**CITY OF PORTLAND, MAINE
DEVELOPMENT REVIEW APPLICATION
PLANNING DEPARTMENT PROCESSING FORM**

Great Diamond Island (lot#69)

MEMO

To: Jay Reynolds
From: Richard Lo
Date: October 12, 2004

1 SILT FENCE DETAIL

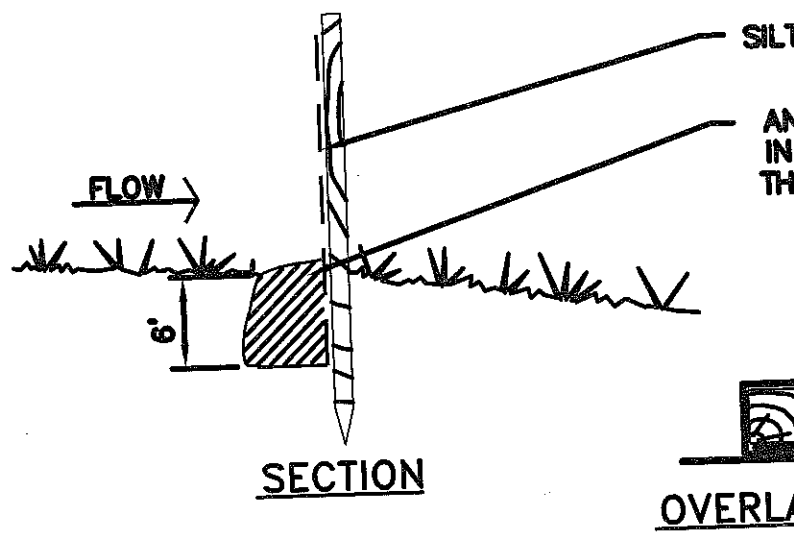
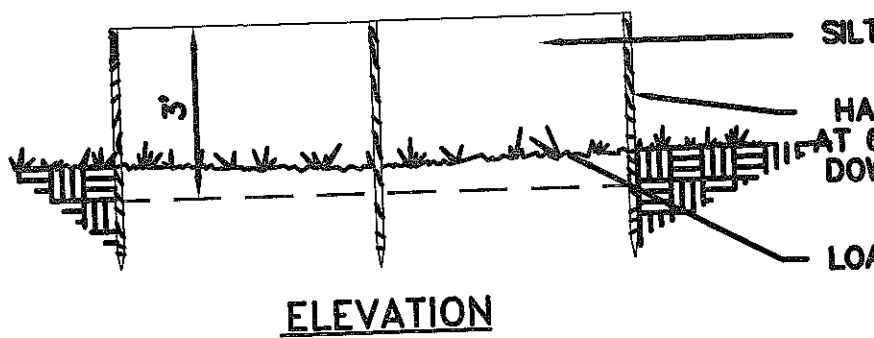
1. The location of the house relative to the Spring High Tide Line, and
2. Measures to control silt run-off from the site during the construction period.

The site plan also notes the location & extent of a Silt Fence, to control run-off from the site during construction. A detail of the proposed fence is also included here for your consideration.
